# Tallawong Station Precinct South

Response to Submissions: Engineering Items

Client: Landcom

17-Oct-2018

INSET 5 - RIGHT TURNS
Scale 1:250

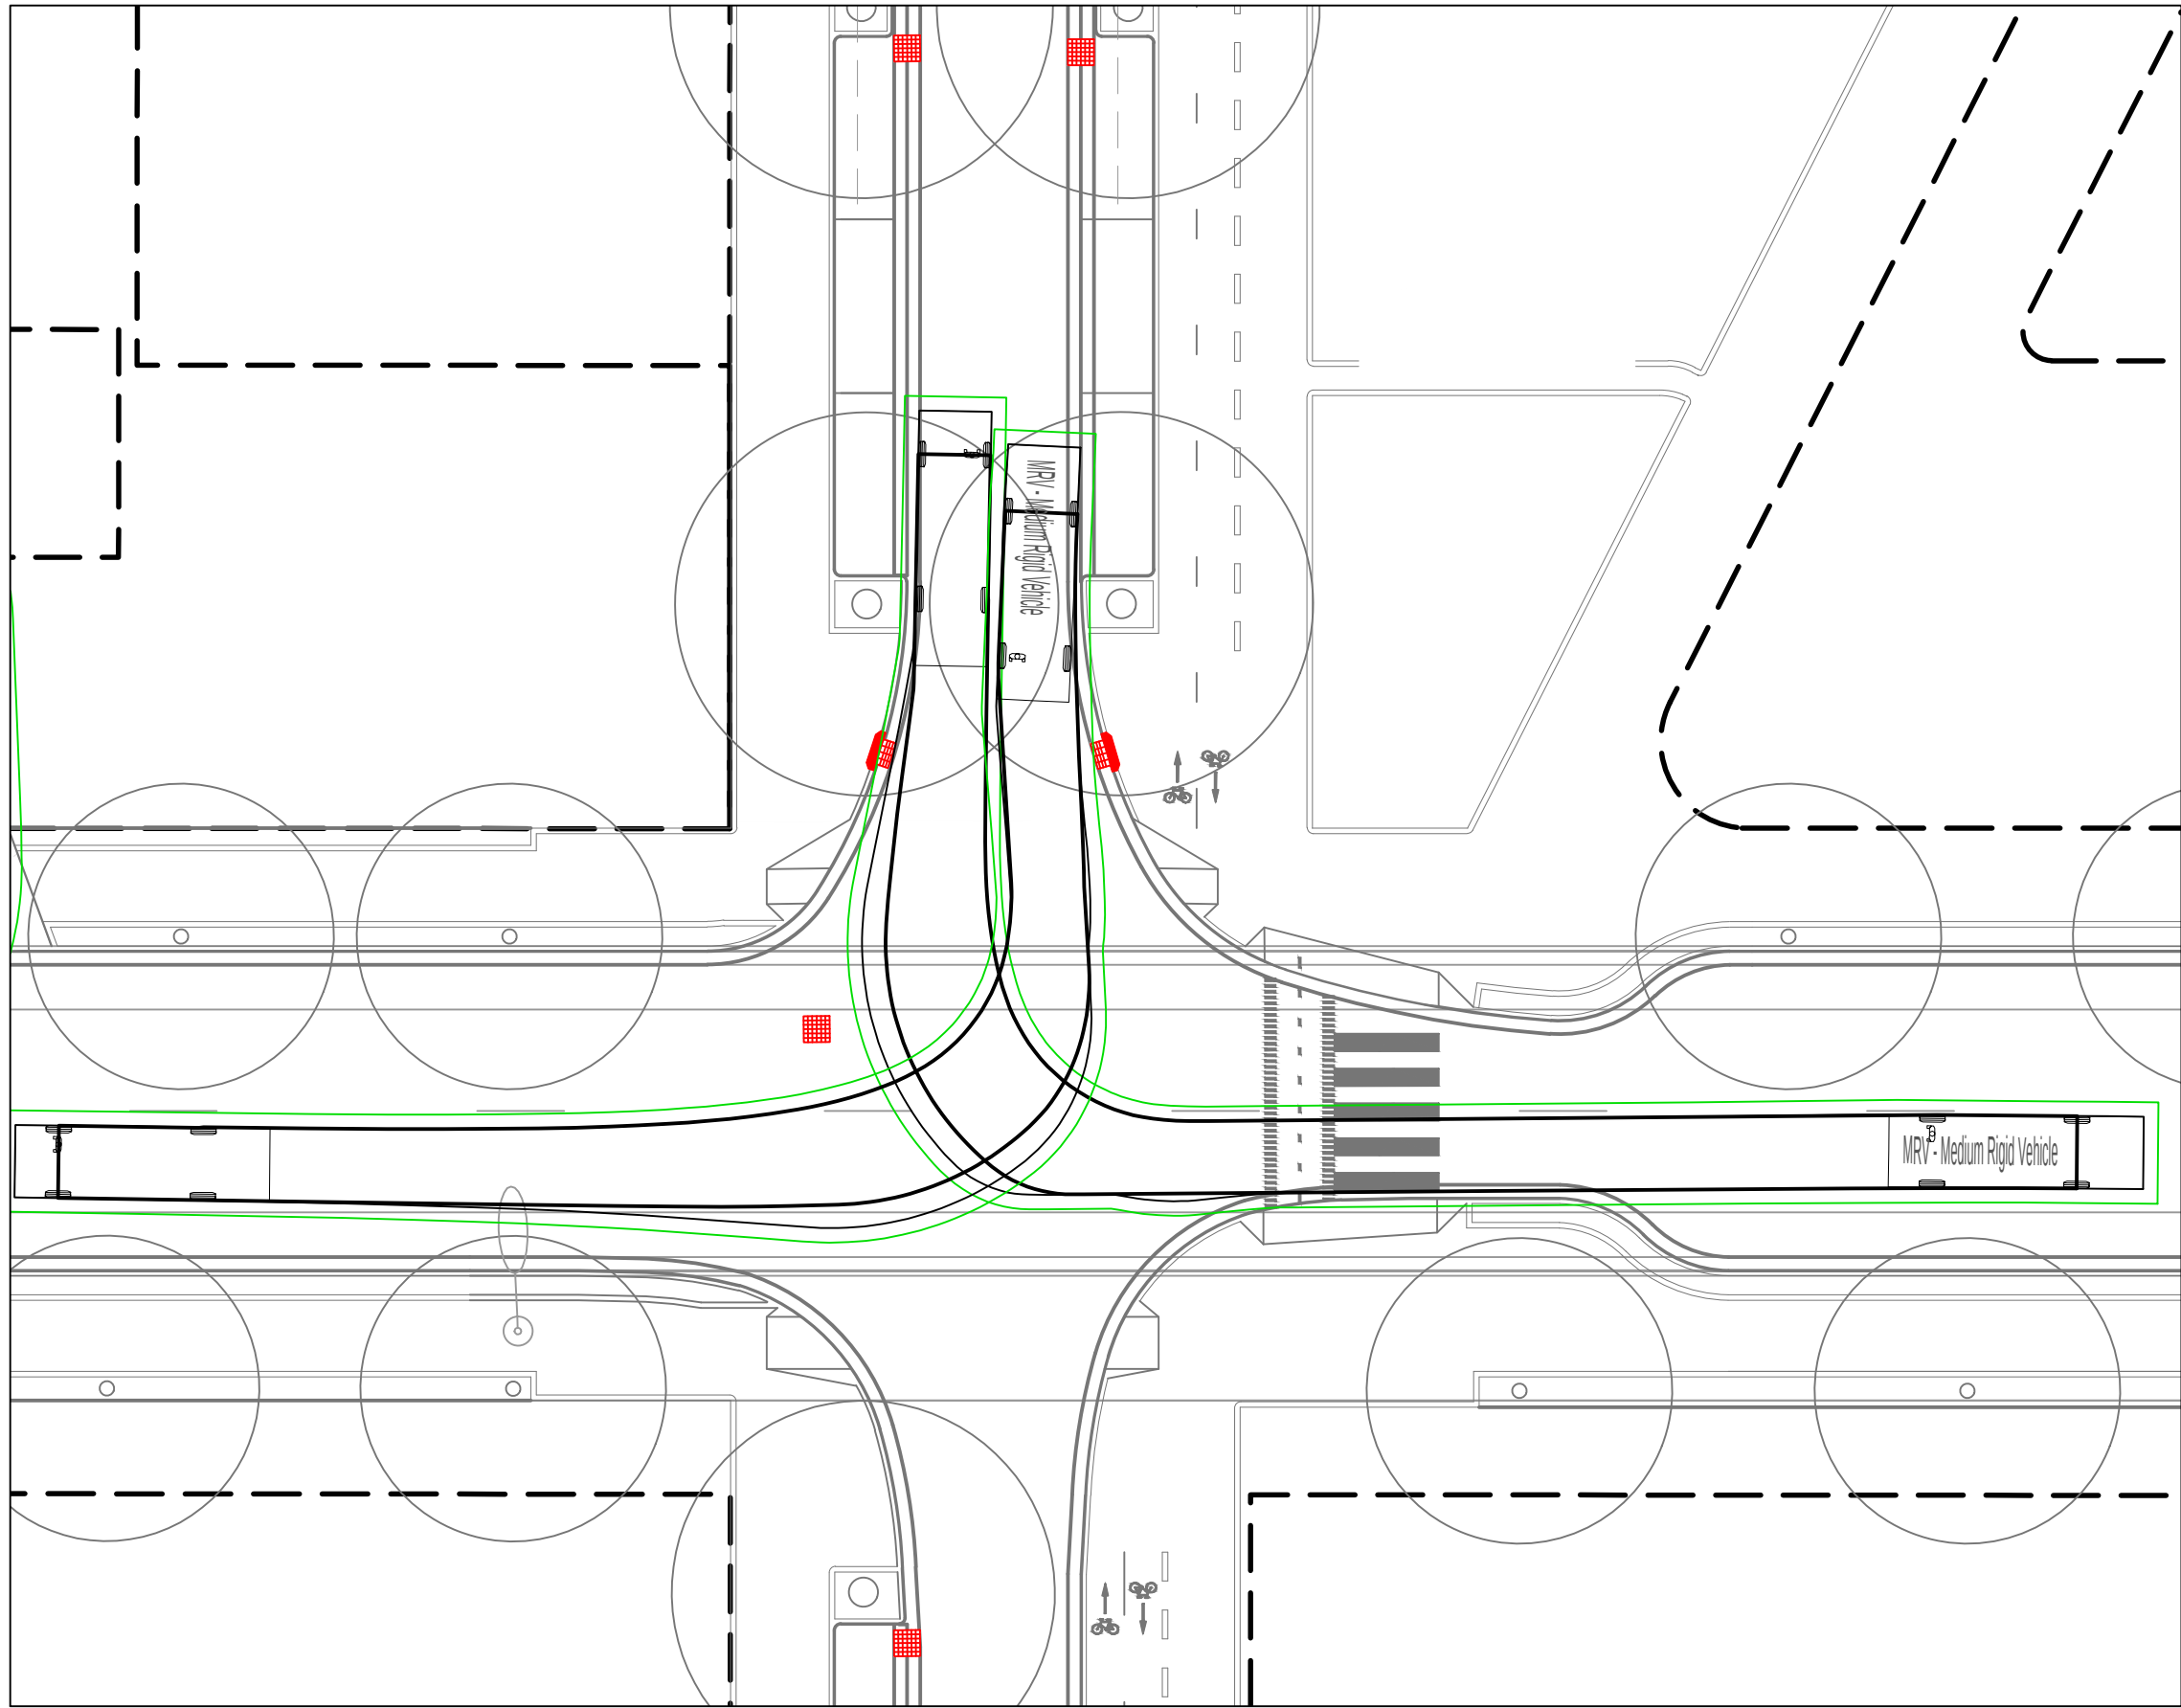
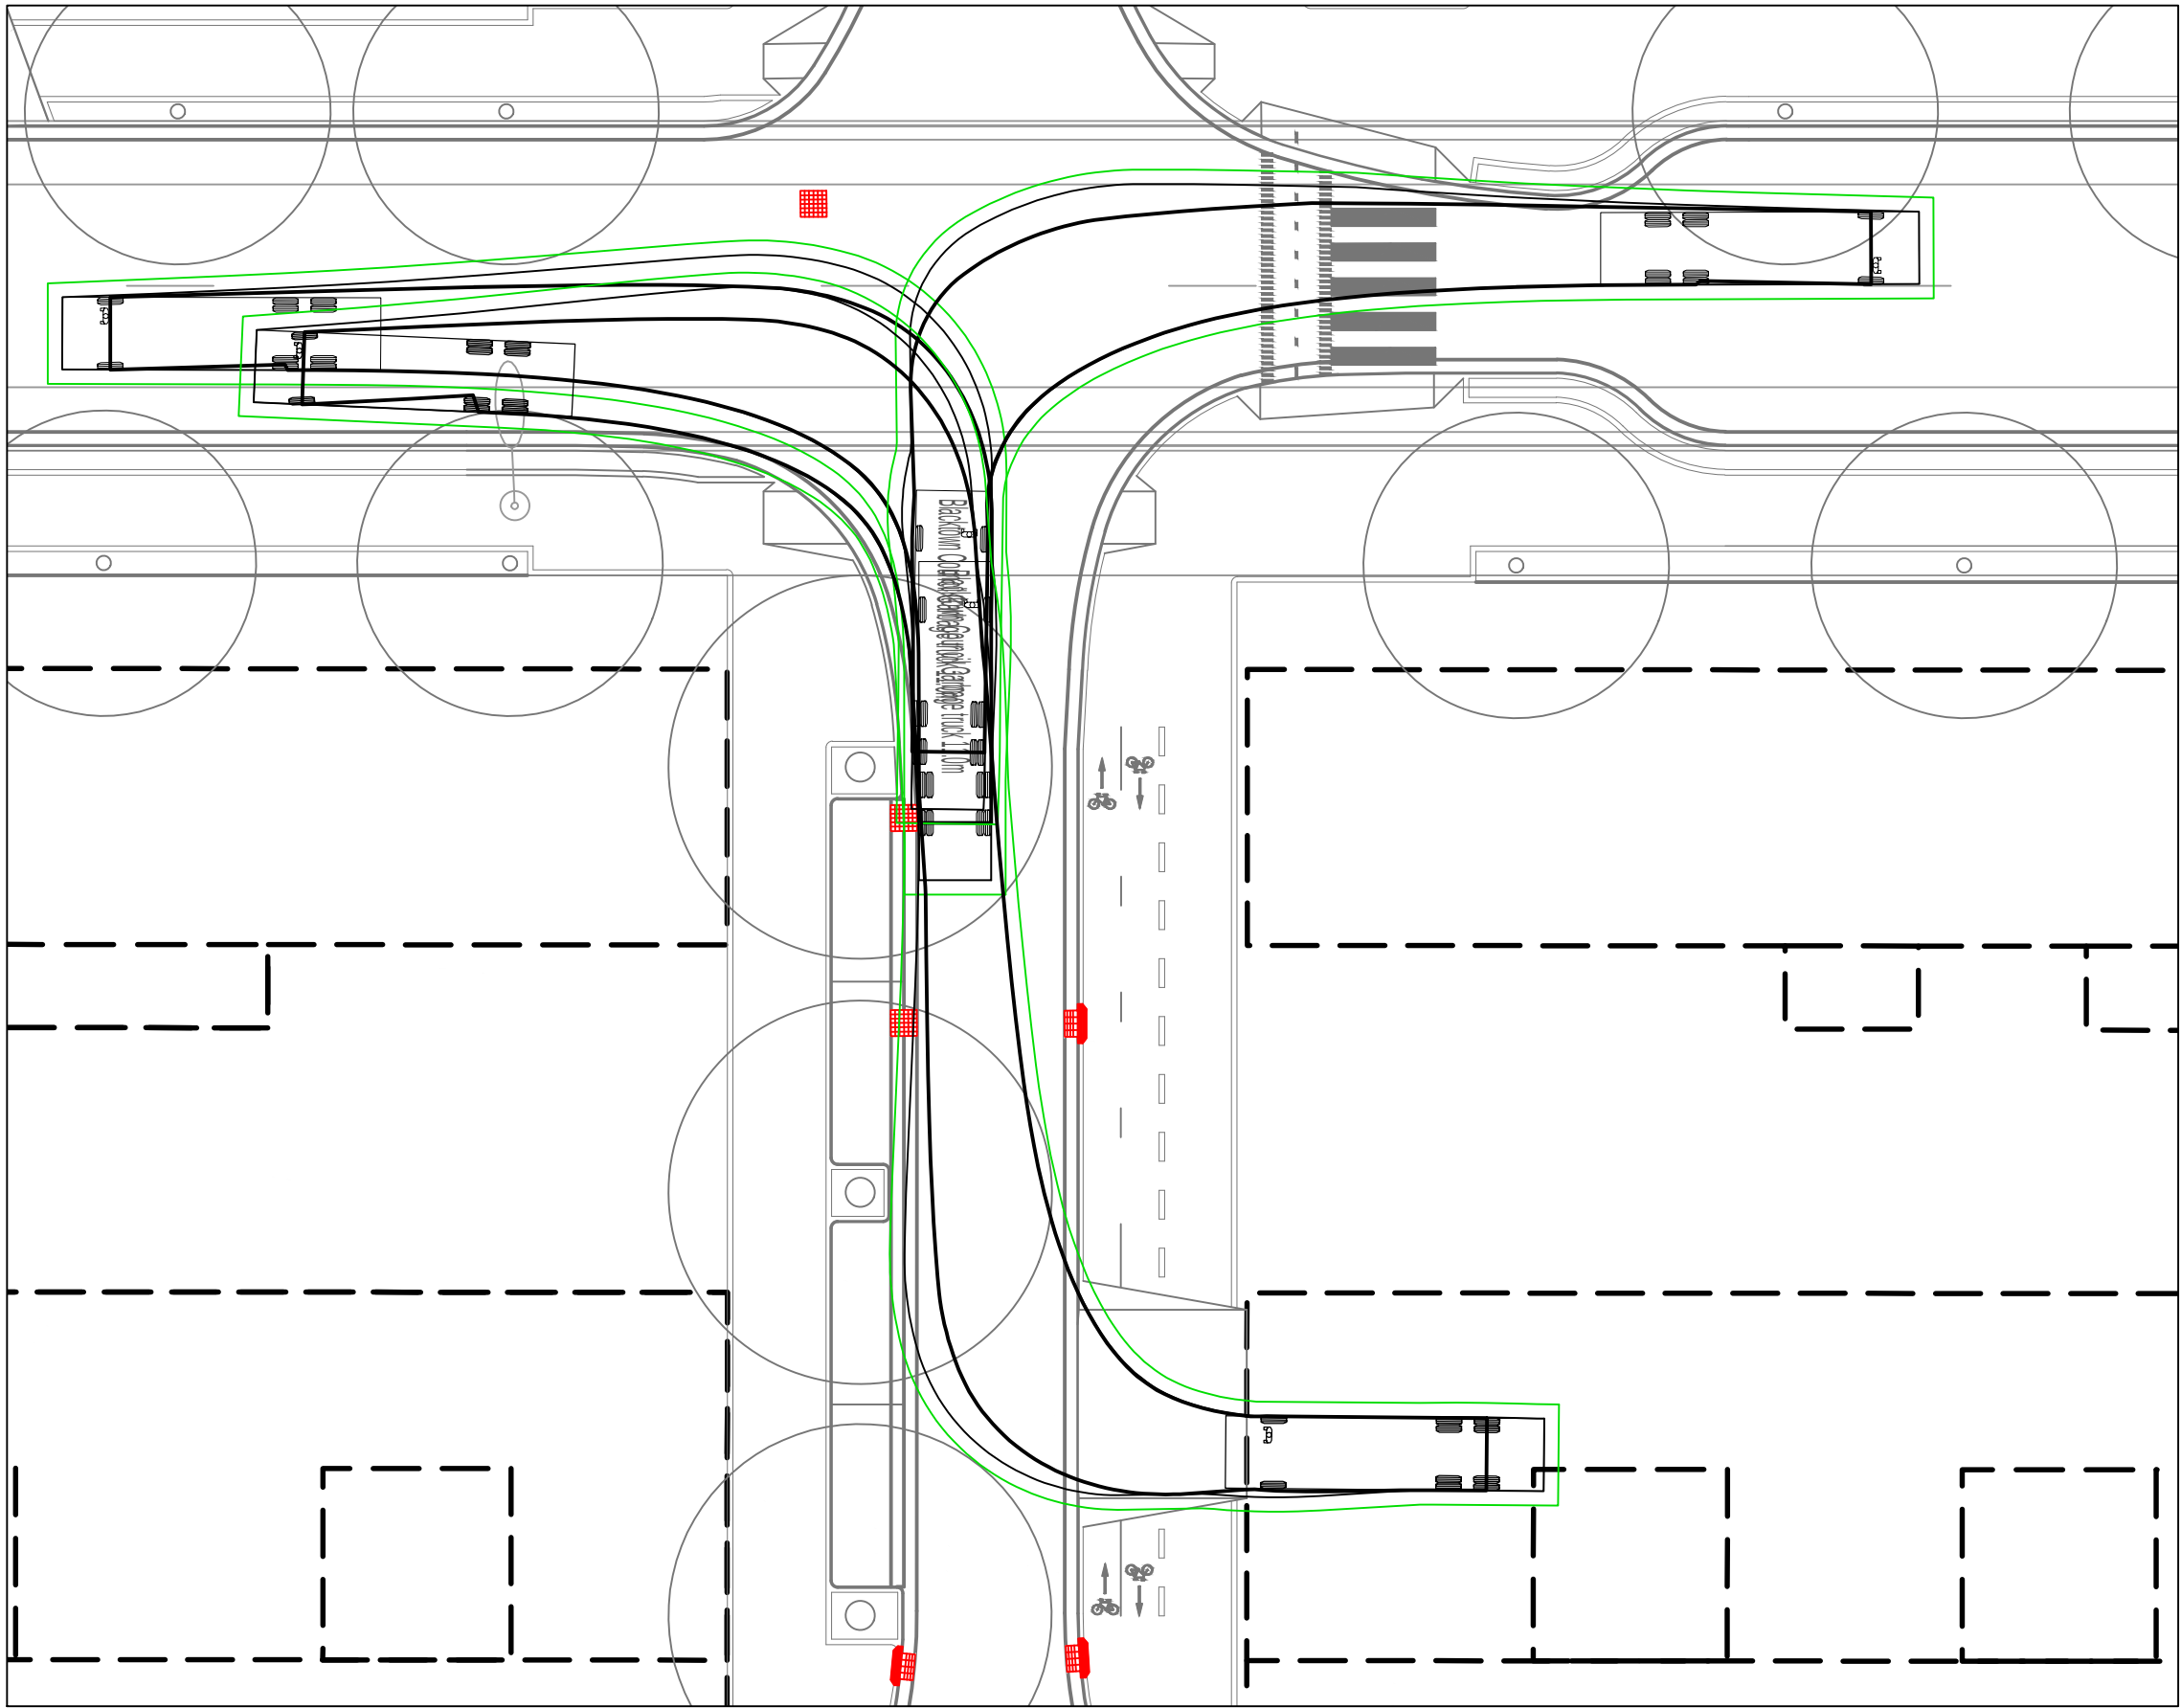
*vi. Demonstrate that the proposed 3.0m lane widths are adequate for larger vehicles such as buses, refuse and service vehicles*

These tracking plans demonstrate that the proposed 3.0m lane widths are adequate for larger vehicles such as buses, refuse and service vehicles.

2 | SECTION B
CI-0021 | SCALE 1:100

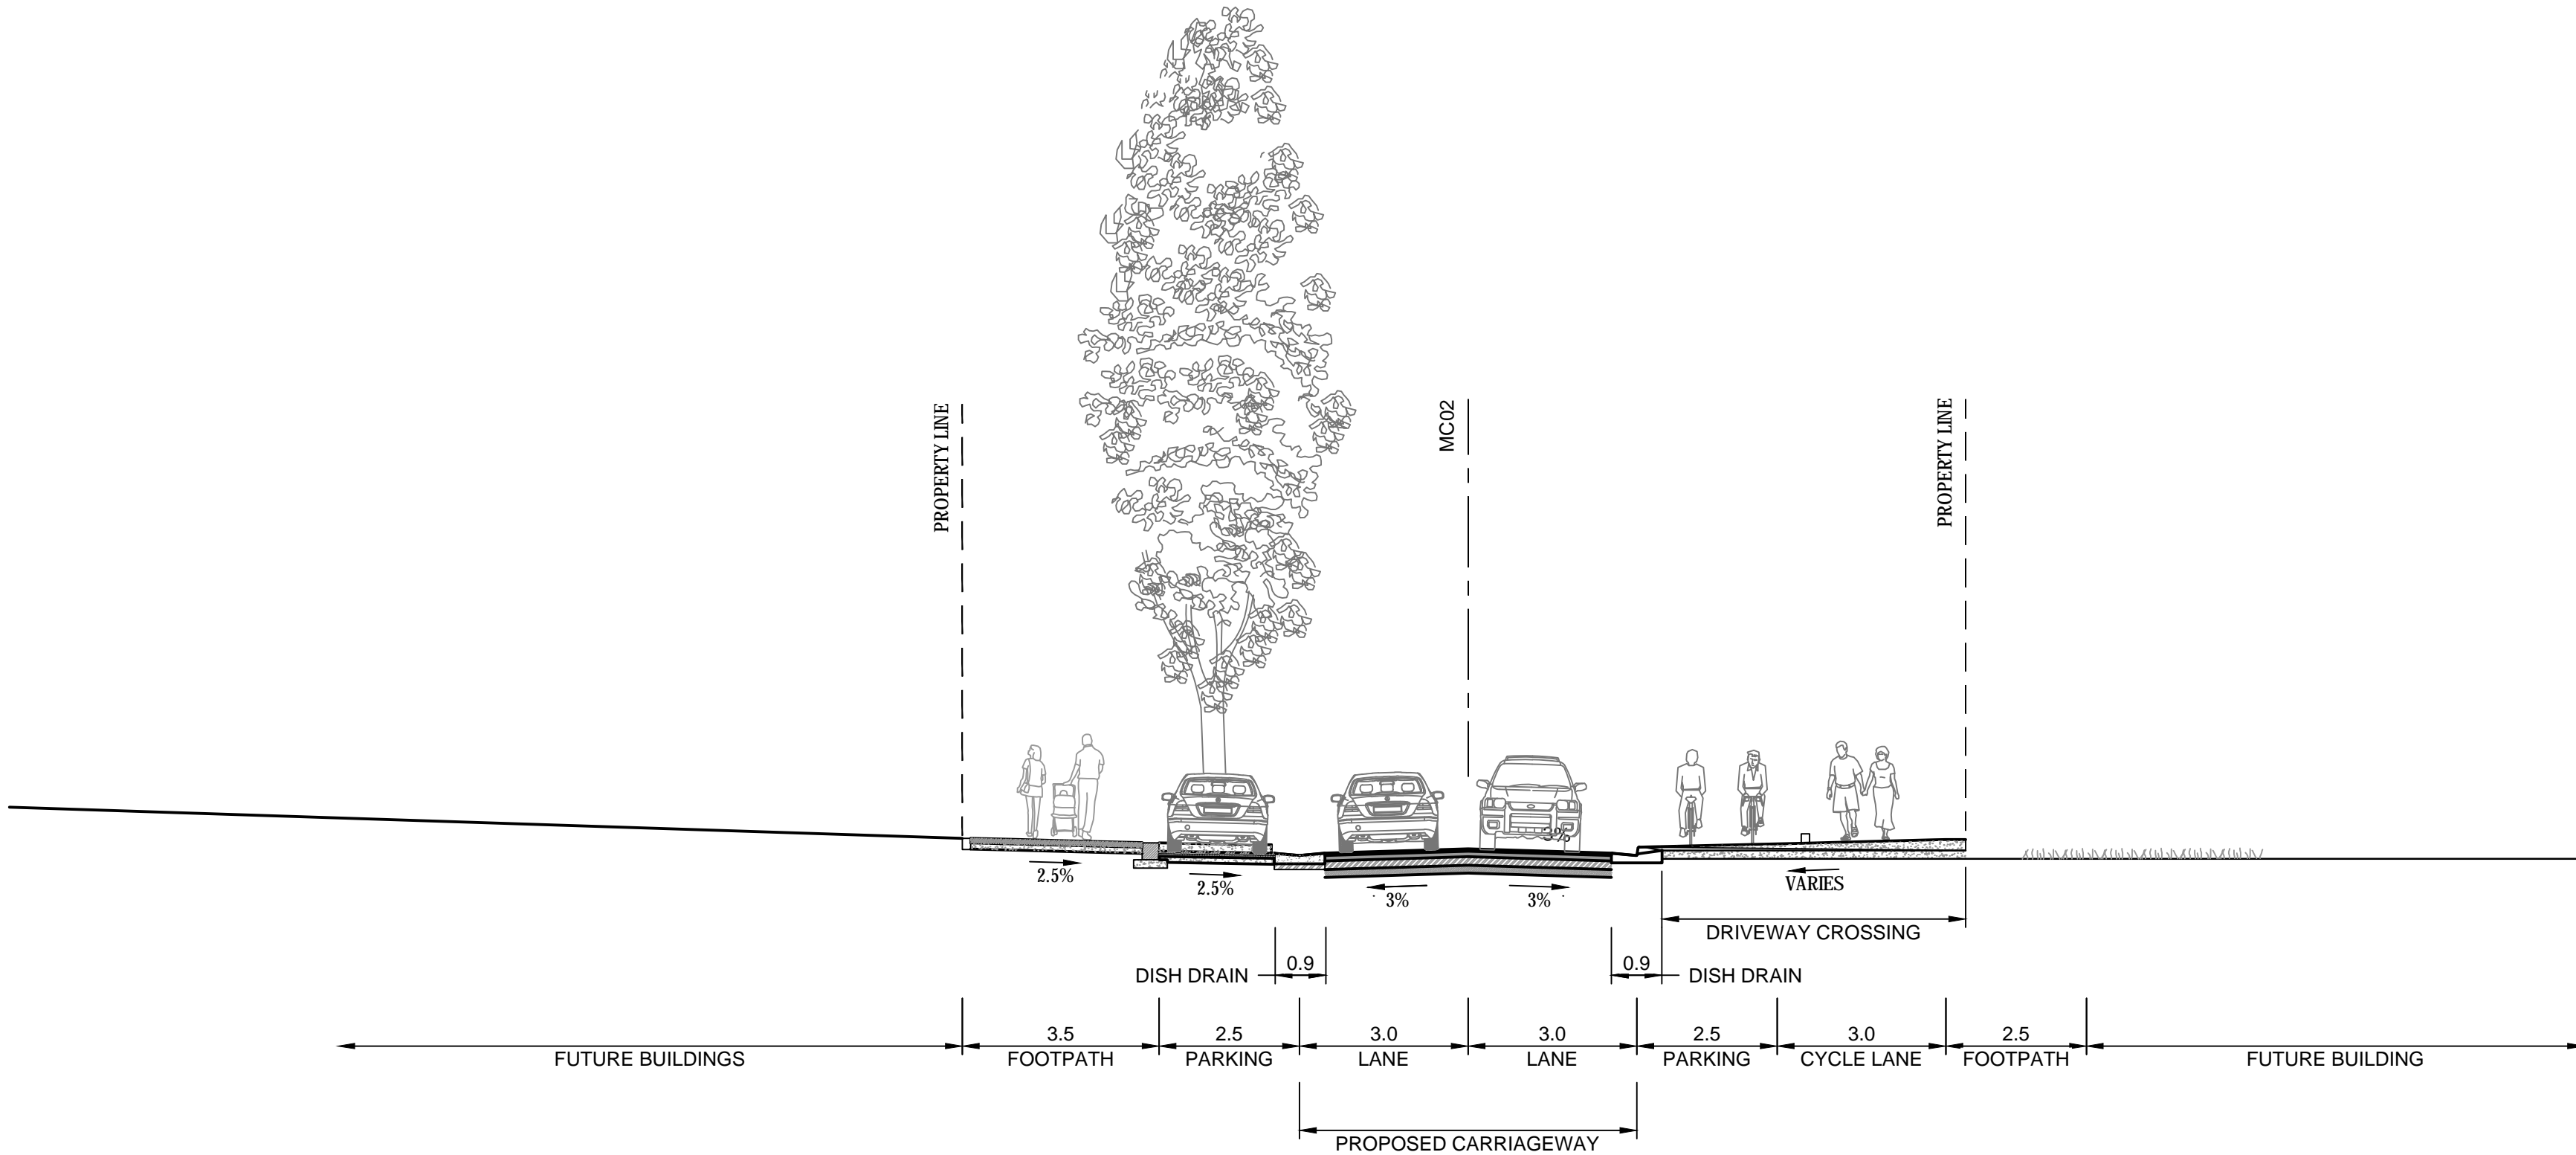
*All local road footpaths are to be minimum of 1.6 m and this is to include the adjacent SP2 and RE1 area which must be a minimum 3.5 m wide. There is no justification for any reduction in the footpath widths.*

- 60558549-SHT-CI-0121 – Section B has been amended to remove the parking reference where the cycle lane is located, footpath has also been correctly shown as 3m width;
- 60558549-SHT-CI-0123 – Section F has been amended to show the correct setback distance of 10m; and
- 60558549-SHT-CI-0123 TYPICAL – In consultation with Blacktown City Council (BCC), the footpath width in Section H has been reduced to 3m to allow a 2m landscaped area.

All road verge widths are a minimum 3.5m (when including footpaths) and local road footpaths are a minimum of 1.6 m wide, refer to the following civil drawings:
